Preliminary Tree Visual Impact Assessment - Keresforth Road in Dodworth

Please find enclosed my comments regarding the potential tree visual implications of the proposal concerning the visual effects for receptors of the proposed scheme. The following is a summary of the visual effects of the proposed tree removals and tree works.

Drawing Title  
Masterplan

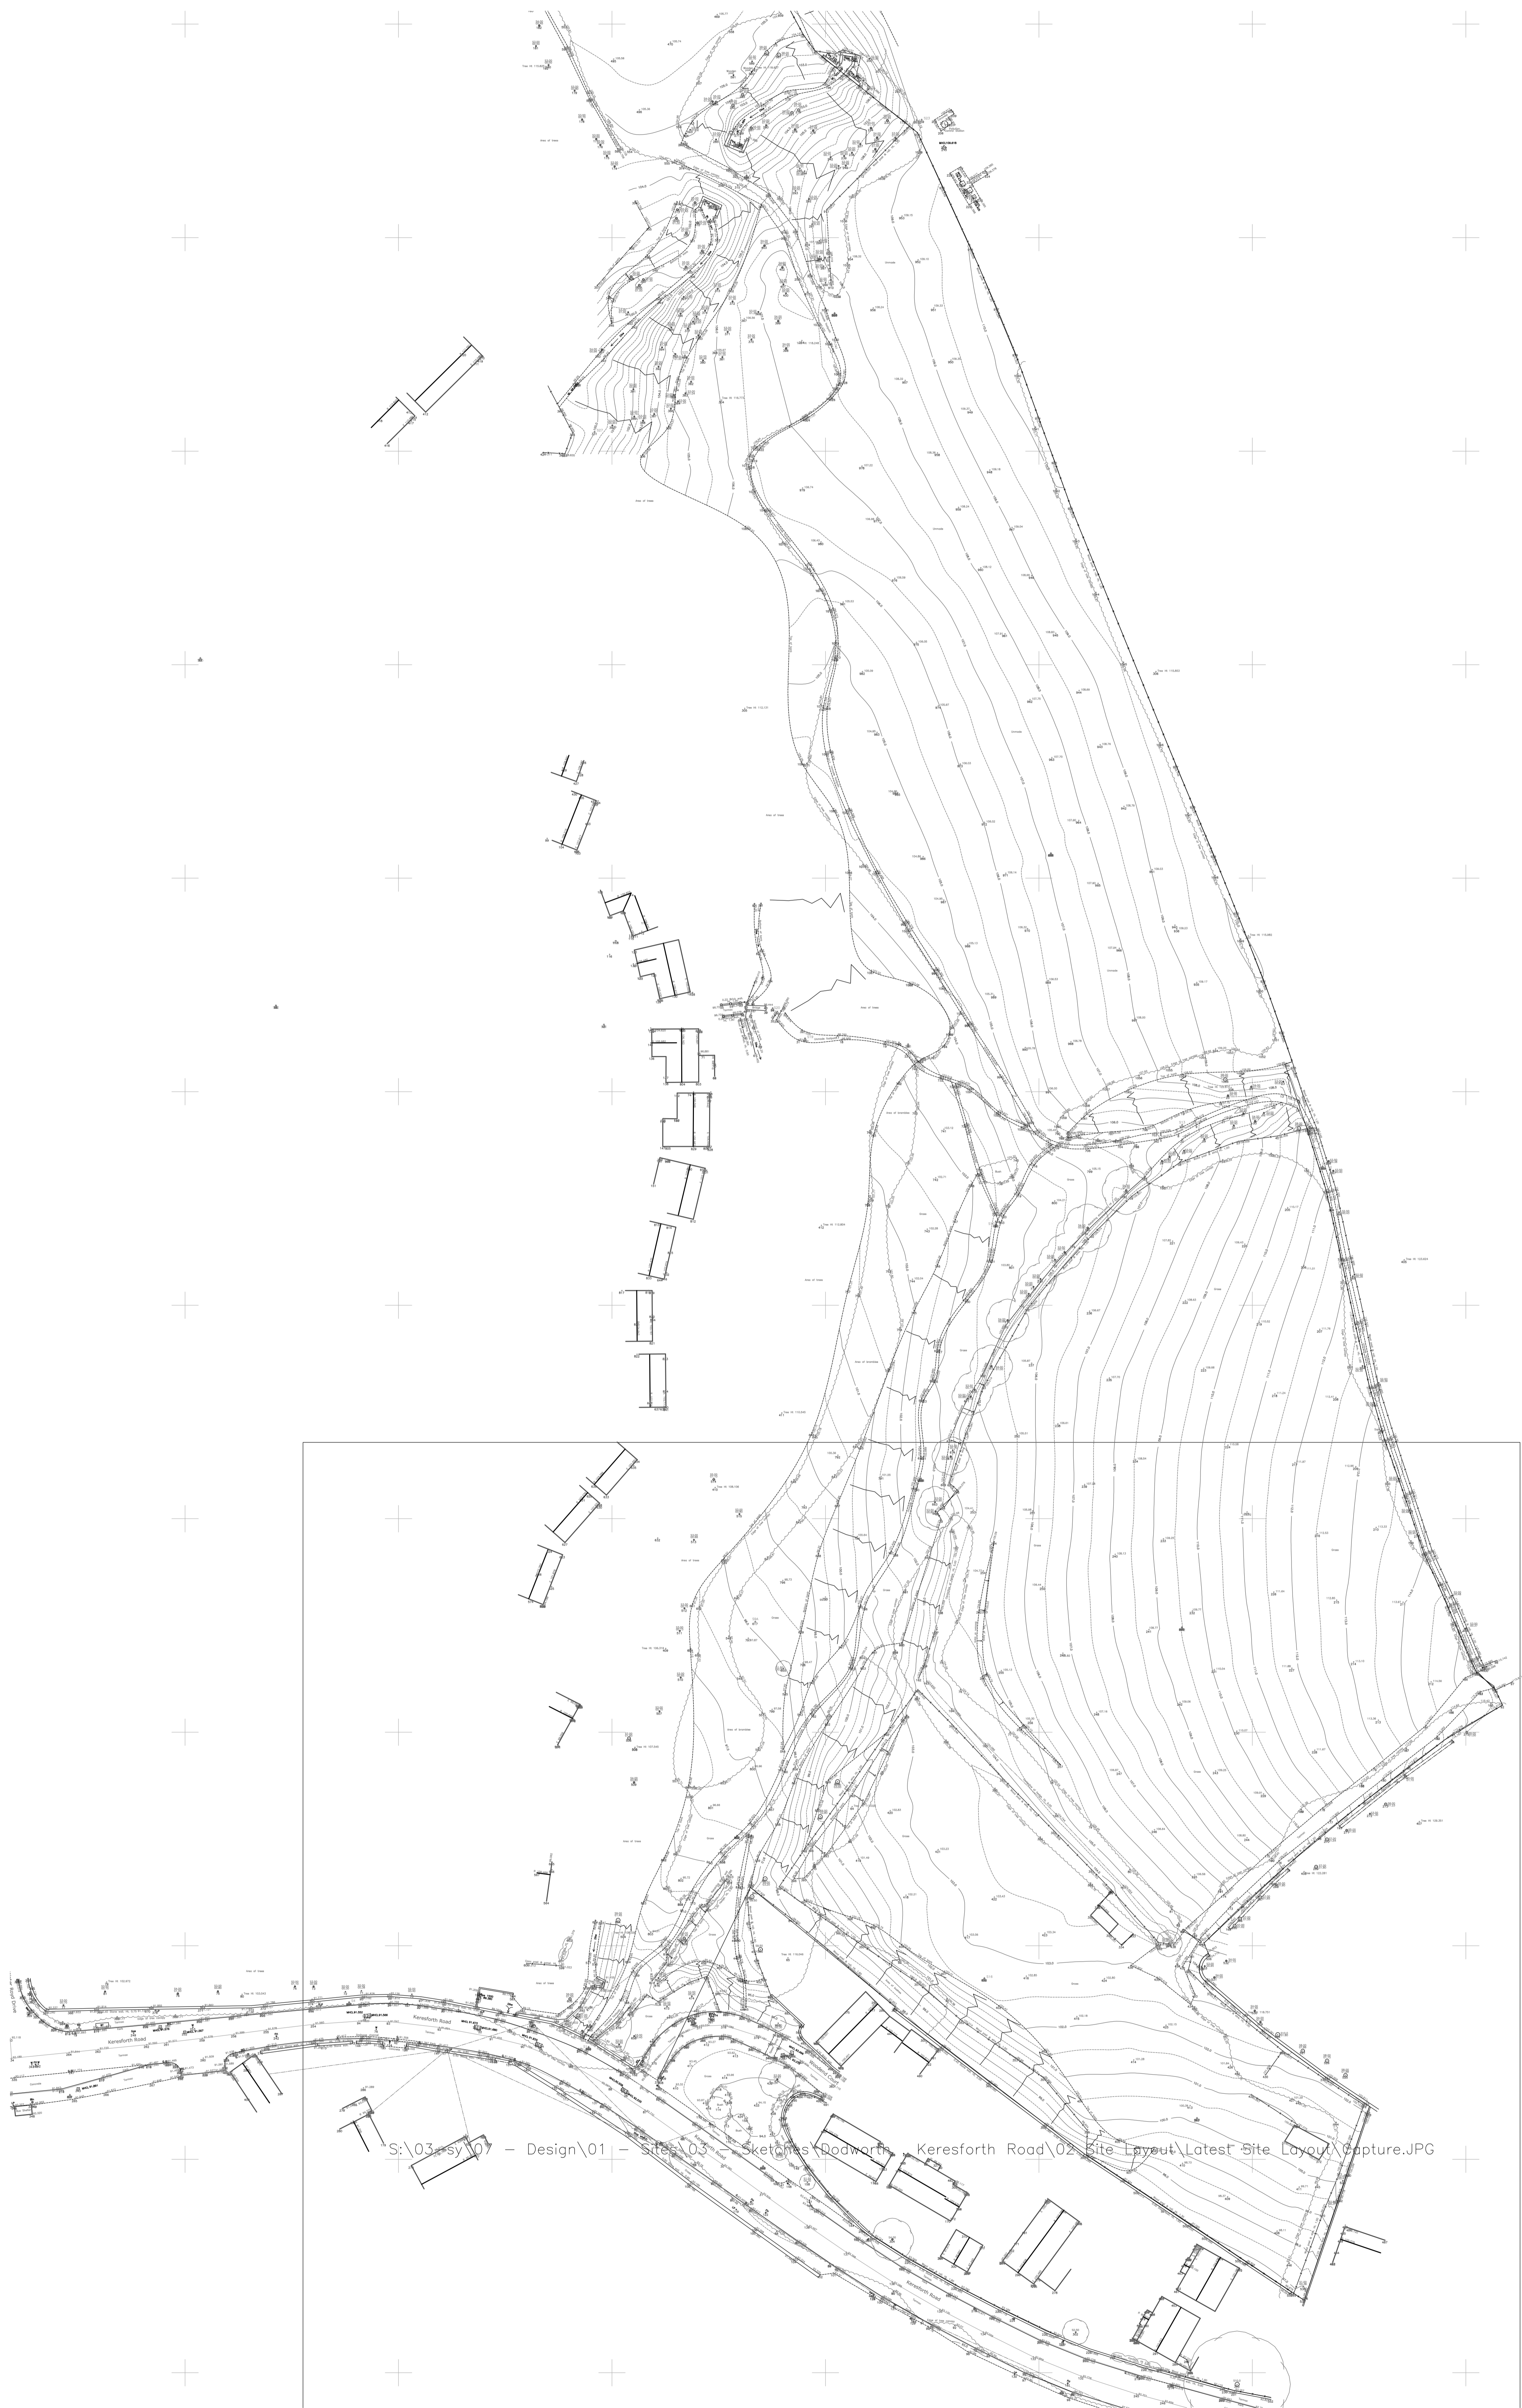
The plan below shows additional tree planting to the front of the site, increasing the extent of planting shown on the original masterplan which will help improve screening. This is suggested additional planting as shown below, to represent large growing stock and trees species.

The tree species should be larger canopy trees such as Large-Leaved Lime, Oak, for example.

This additional planting provides large, canopied trees to help mitigate for the losses in the area close to the proposed entrance and is proposed to help mitigate the required area tree removals, the tree planting numbers to be agreed through reserved matters.

The entrance area would have retained woodland to the west, with a large area of new tree planting to the main entrance area (east). Further tree planting is shown to complement the retained trees providing connectivity of trees into the site providing a green corridor.

The additional planting will provide a small woodland feel to the entrance area, using an additional twenty-seven trees. This planting should be enhanced with understory planting of naturalised bulbs and shade-tolerant grass seed mix. The use of understory shrubs could be considered though the feeling of safety to more vulnerable users would be impacted, and use of the space may be reduced. The visual impacts (of removed trees) for nearby highway users with the additional planting would therefore be reduced.

Tree Constraints Plan showing tree categories and root protection zones.

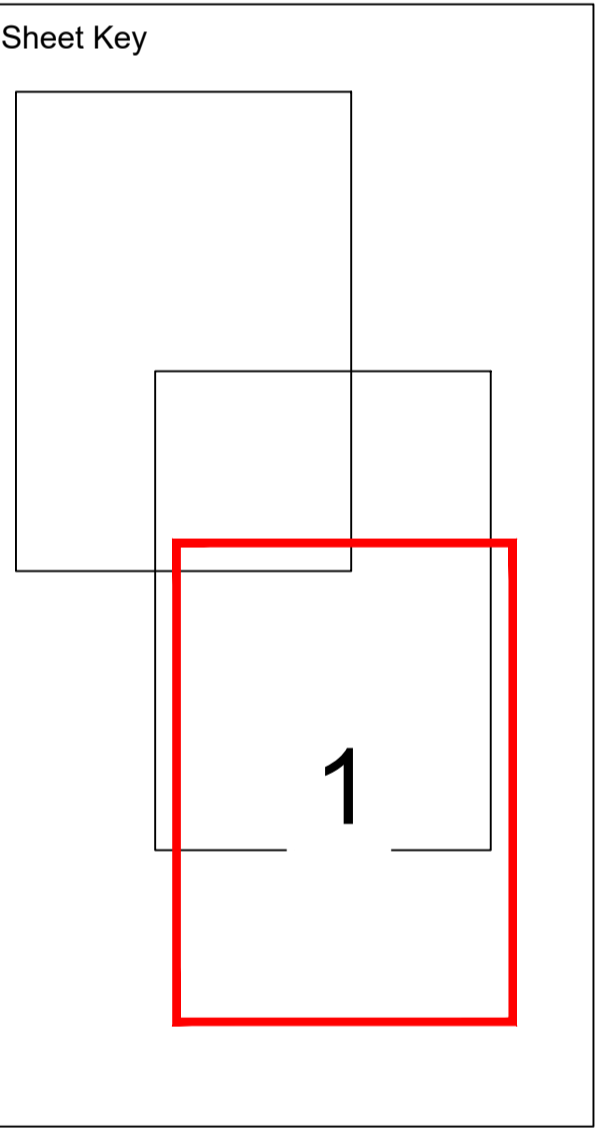
The proposal (shown below) requires the removal of the majority of trees bordering Keresforth Road. The trees to be removed are highlighted in red, copied from the arboricultural impact assessment BA11799.

Tree Mitigation - The arboricultural impact plan BA11799AIA_A extract is shown below
This shows the following trees losses and their details are provided in appendix A.
